Our Ref: 718742  
DPIE Ref: DA220-07-2002-I-Mod-12  
RFI Ref: RFI-35384212

**RESPONSE TO REQUEST FOR ADDITIONAL INFORMATION – MODIFICATION TO DEVELOPMENT CONSENT  
DA220-07-2002-I-Mod12, 1 DAMPIER STREET, BOWMAN NSW**

On behalf of the applicant, Teys Australia Southern Pty Ltd, please find below a formal response to the request for additional information provided by the Department on 01 February 2022. The below response adopts the points outlined within Attachment 1 of the request.

00A001 - 8

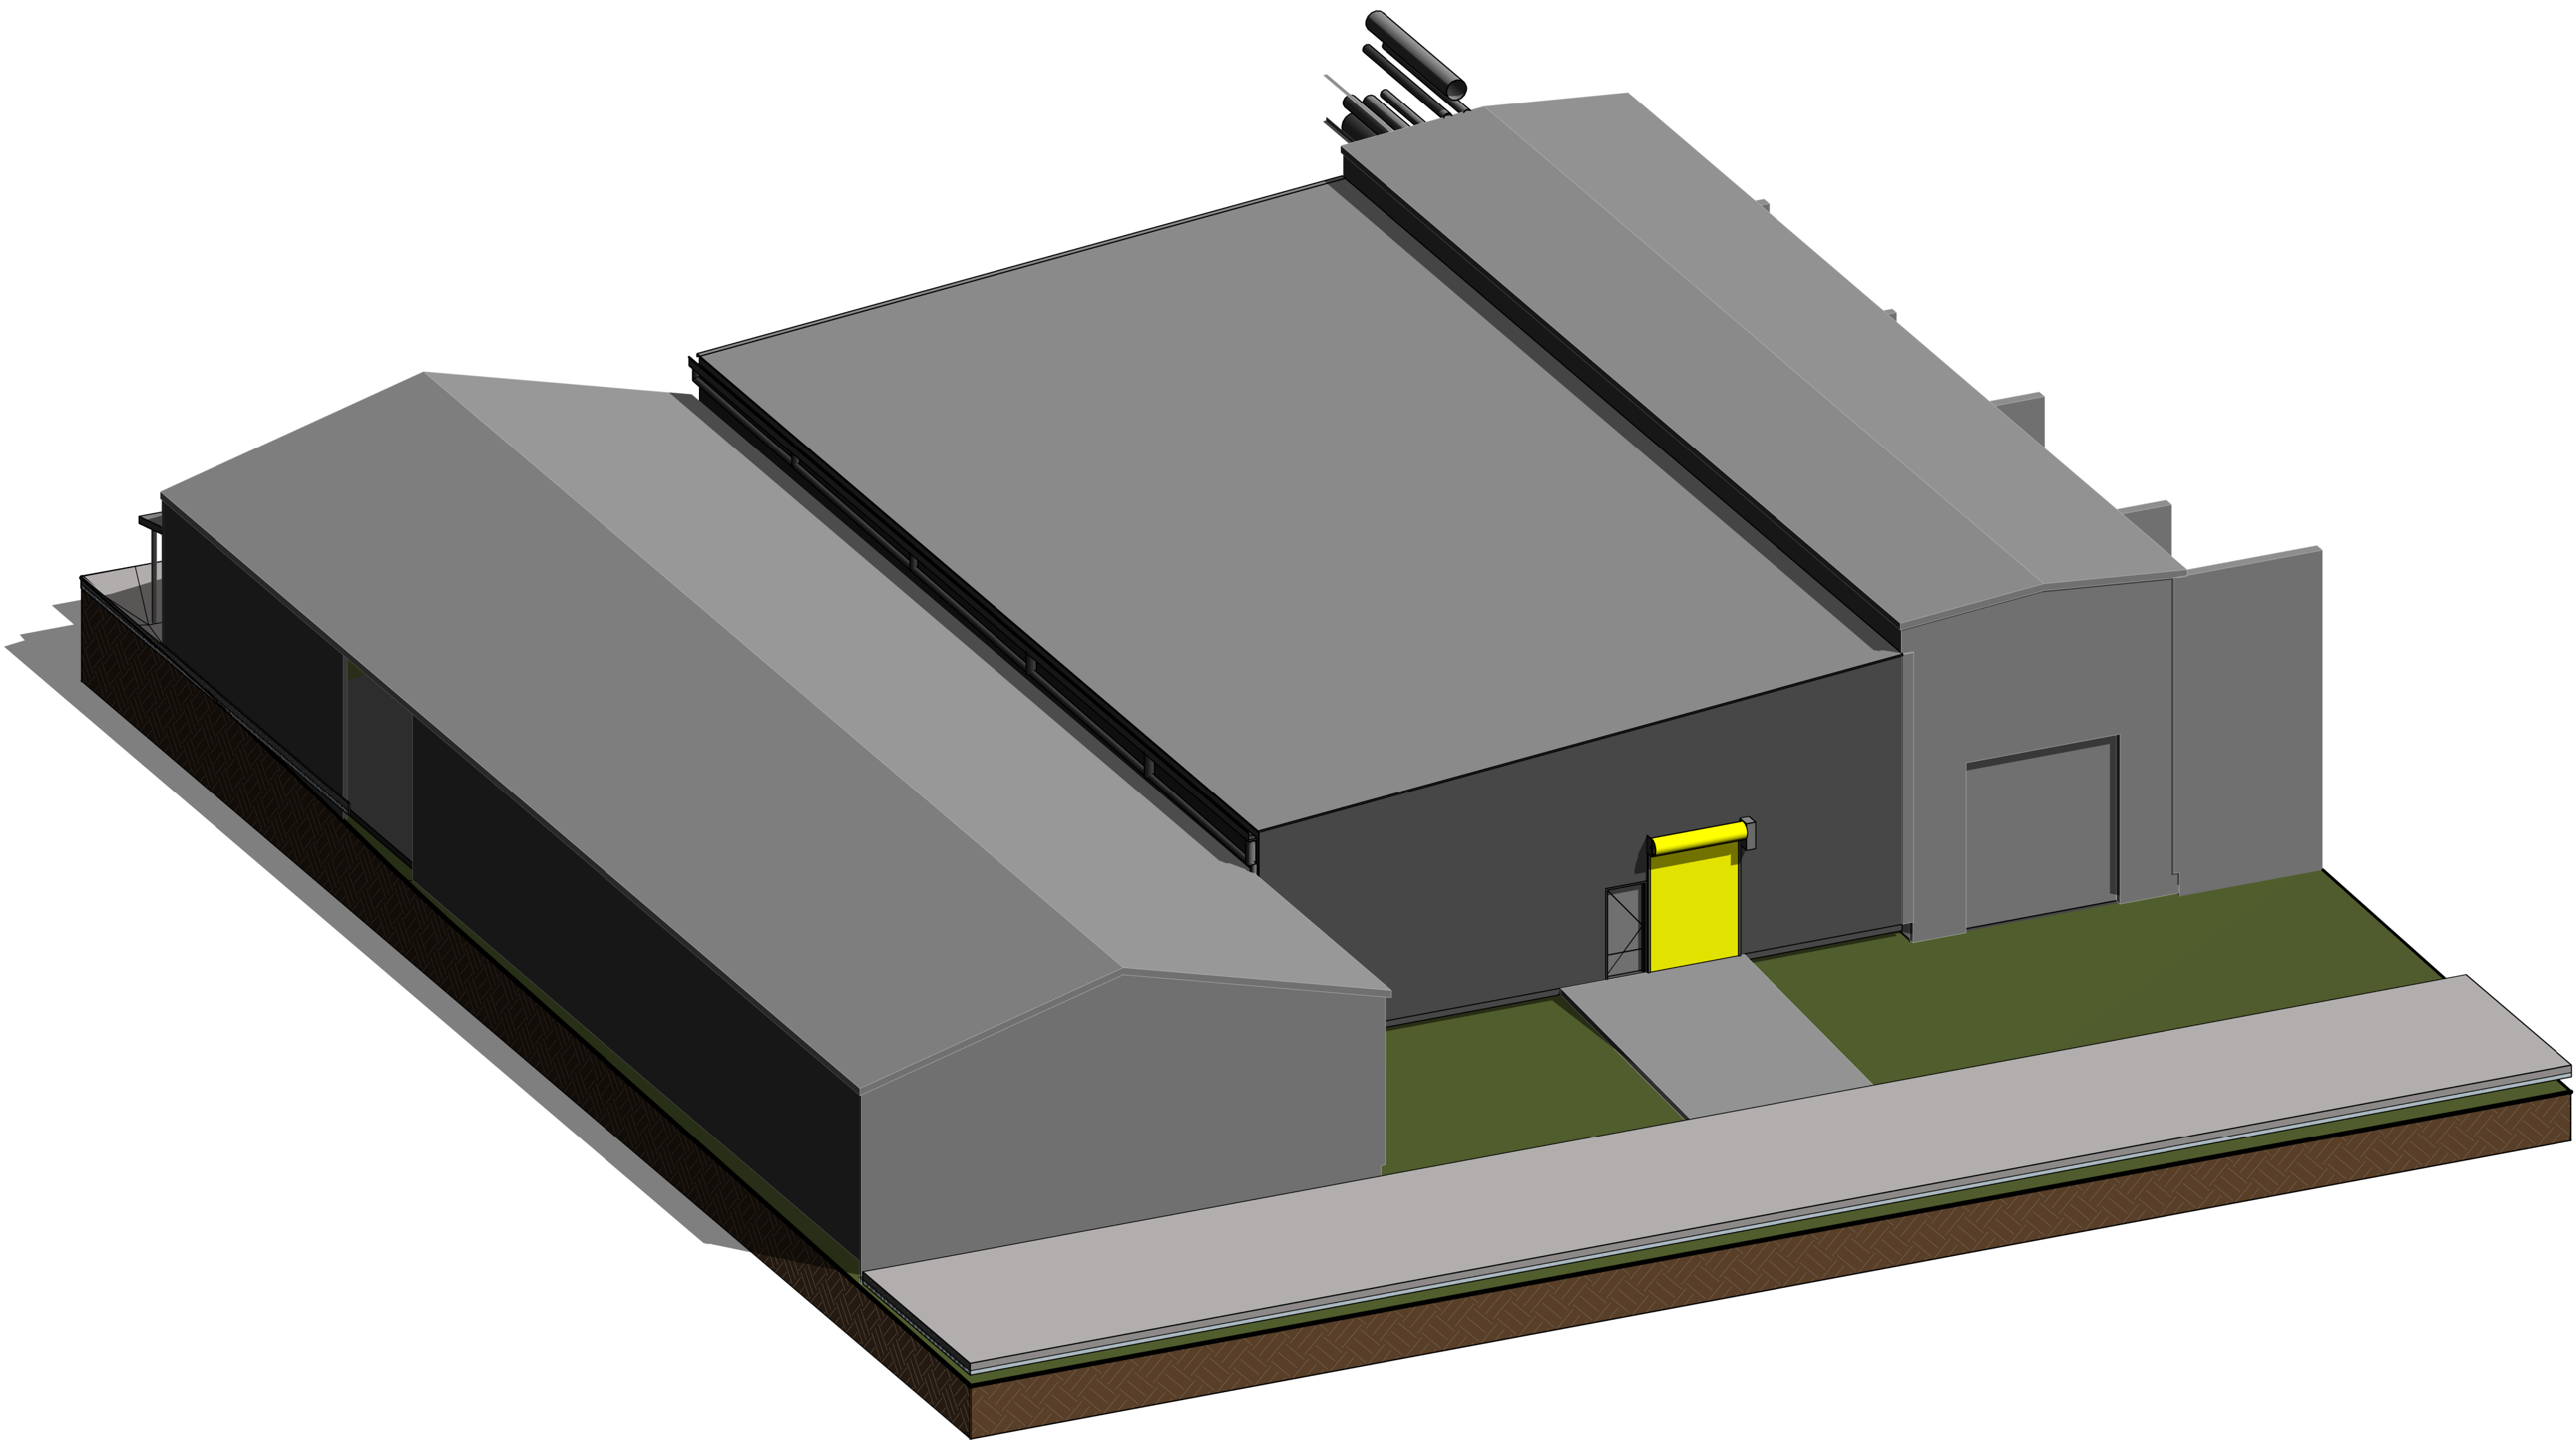
The Report states the total increase in gross floor area (GFA) for the subject site 820m<sup>2</sup>. However, no GFA drawings have been submitted to nominate the proposed overall floor area. Additional architectural drawings are to be provided that include calculations for the GFA of the proposed buildings.

An updated Site Plan has been provided which provides a breakdown of the existing and proposed GFA for each building. The additional GFA proposed totals 965m<sup>2</sup>.

14A201 - 8

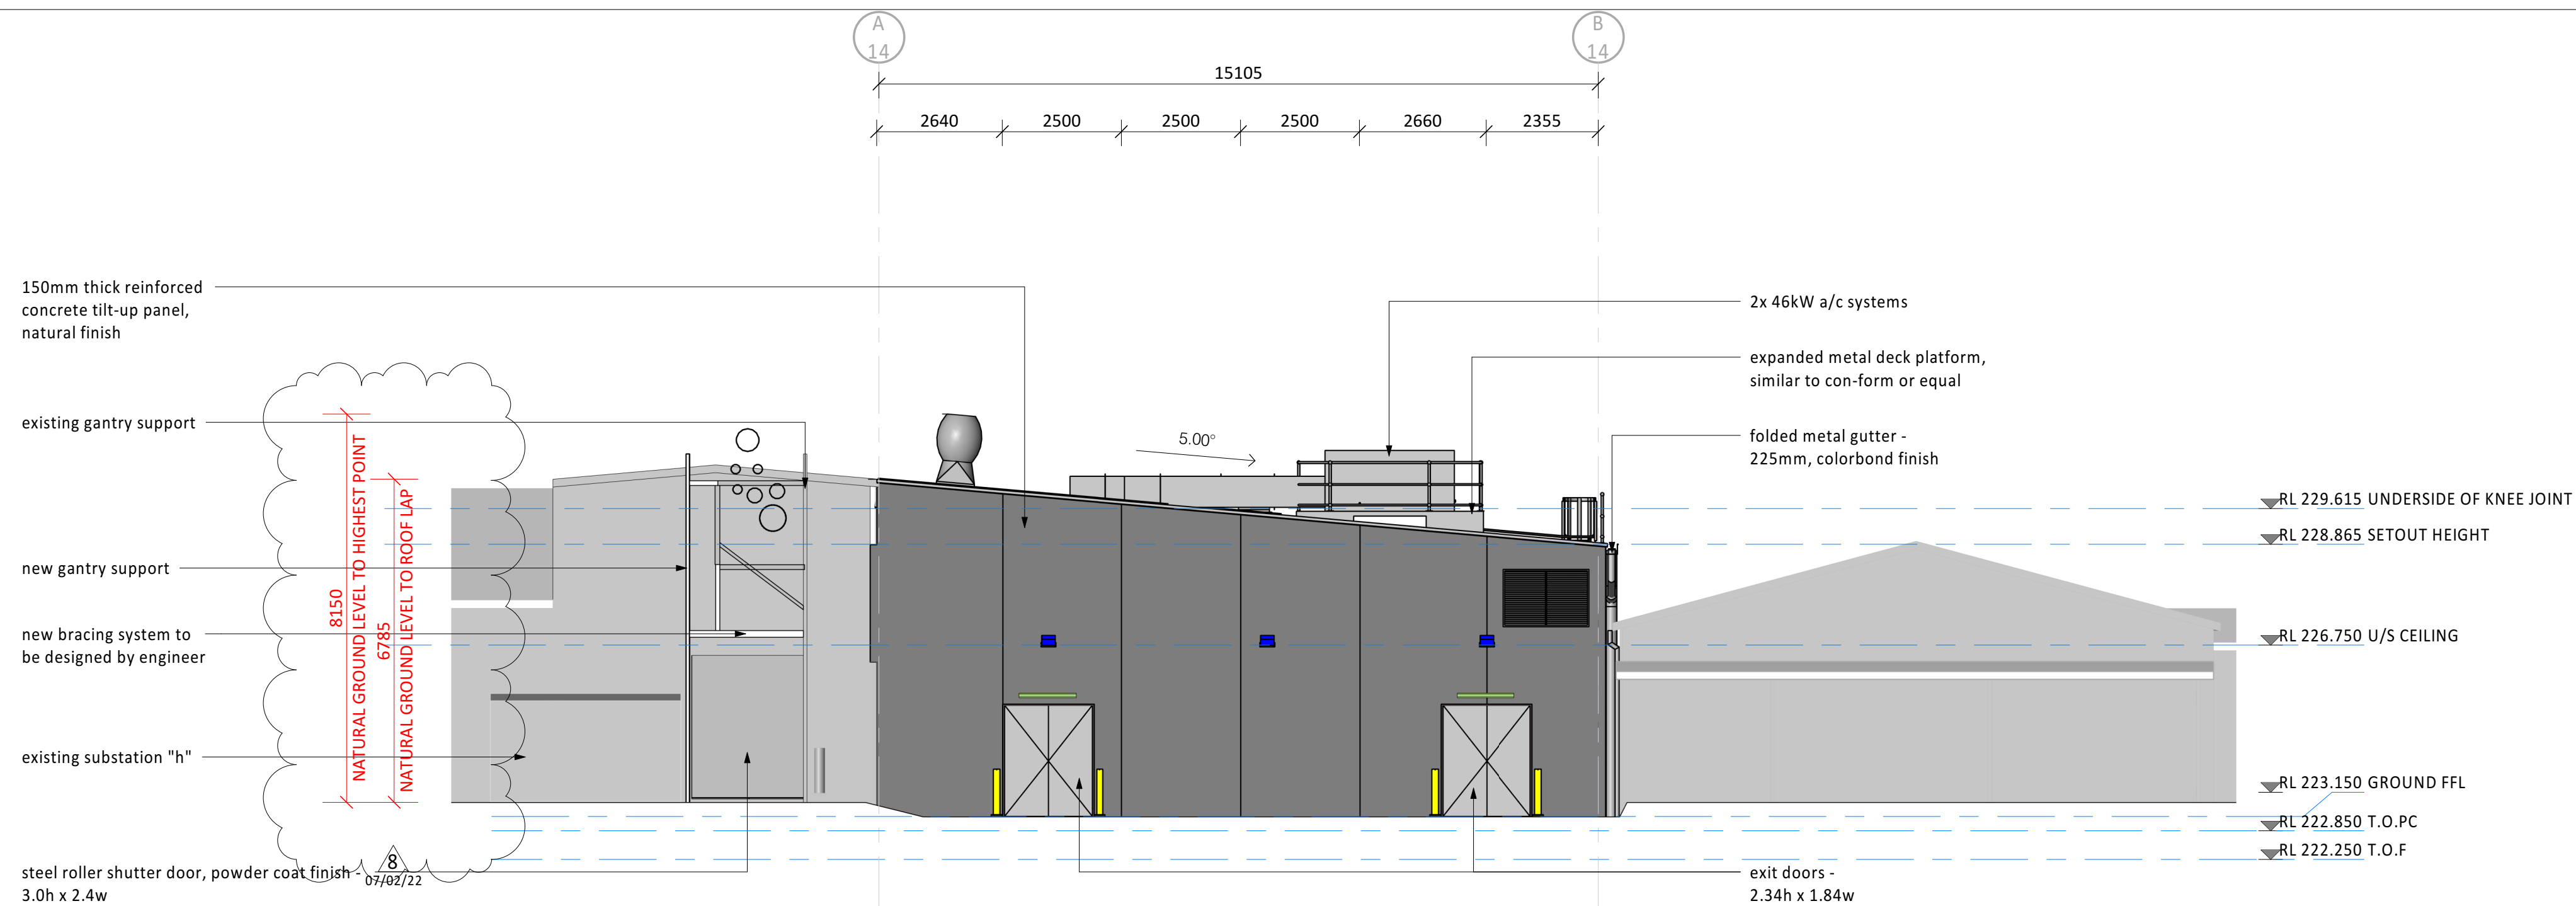
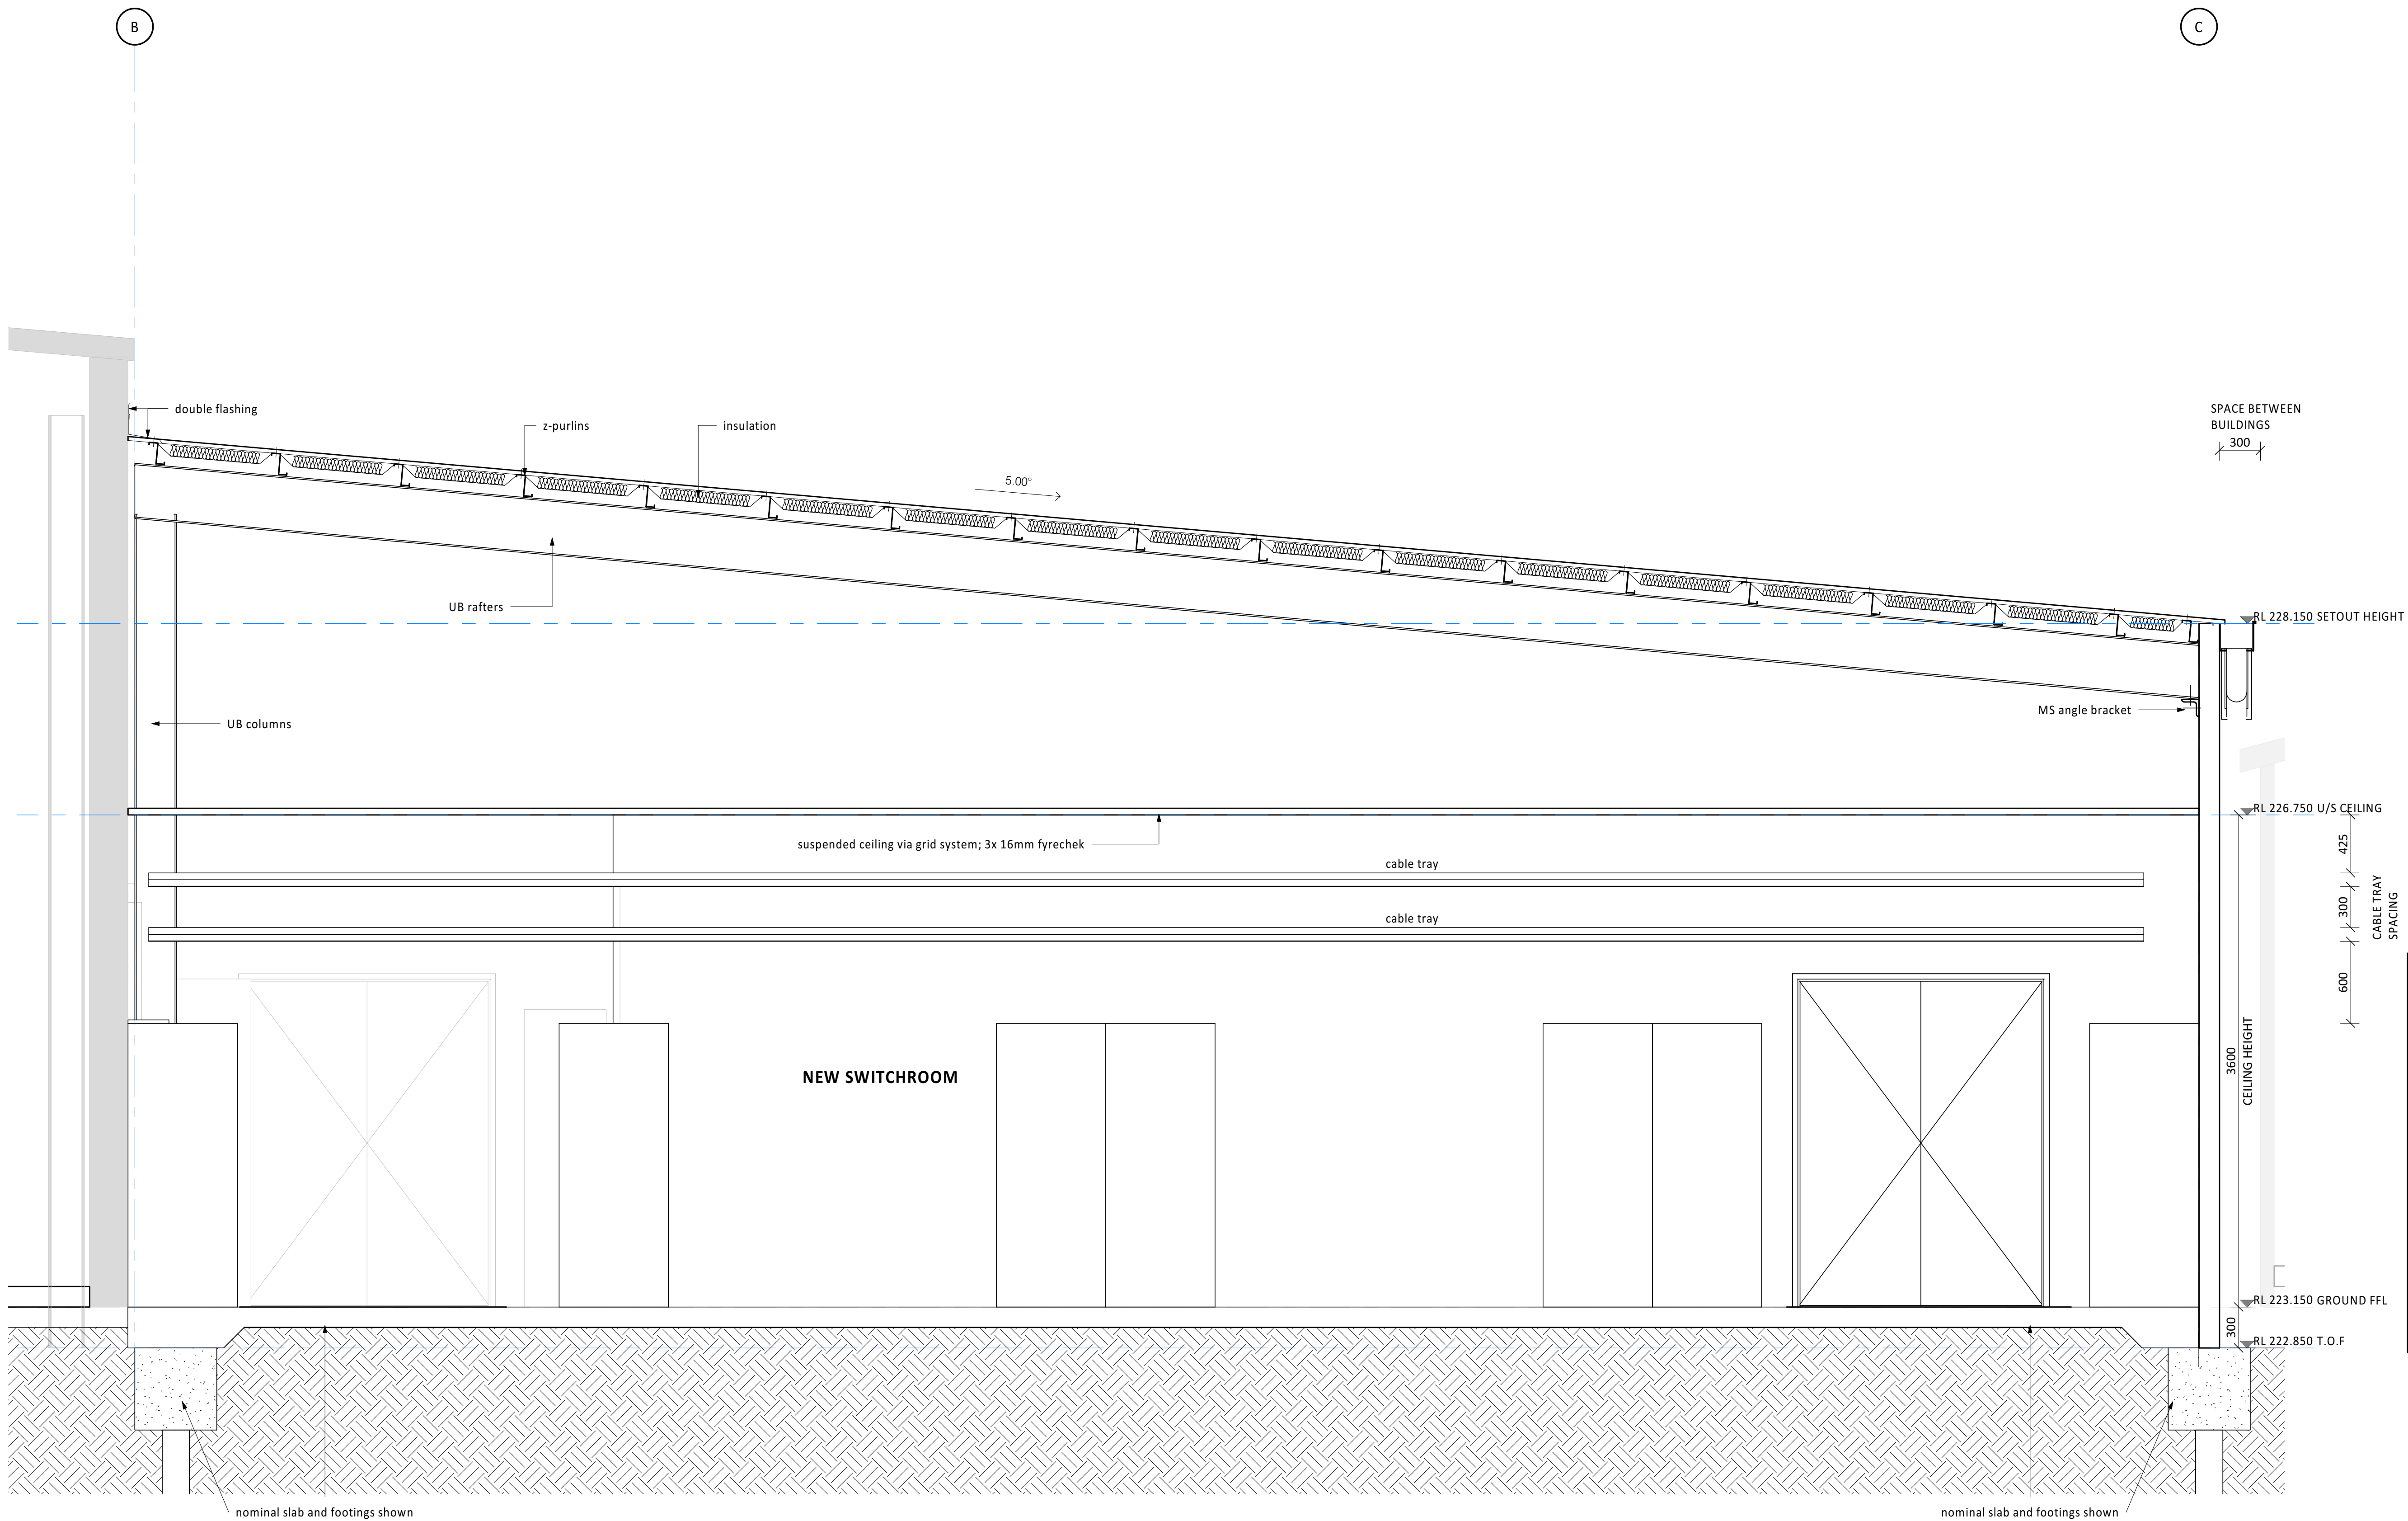
The Modification Report states that one new roller door (3.0m x 2.4m) is to be constructed. However, submitted architectural plans (plan No. 14A201.1) depict two roller doors, one on the northern elevation (2.7m x 2.1m) and one on the southern elevation (3.0m x 2.4m). The Report should be updated to list the correct modified items of works.

The Modification Report has been updated to reflect the two new roller doors. A new roller door is proposed as part of the existing Engine Room and Boiler House on the southern elevation. The new Switch Room / Temp Workshop will include a new roller door on the northern elevation.
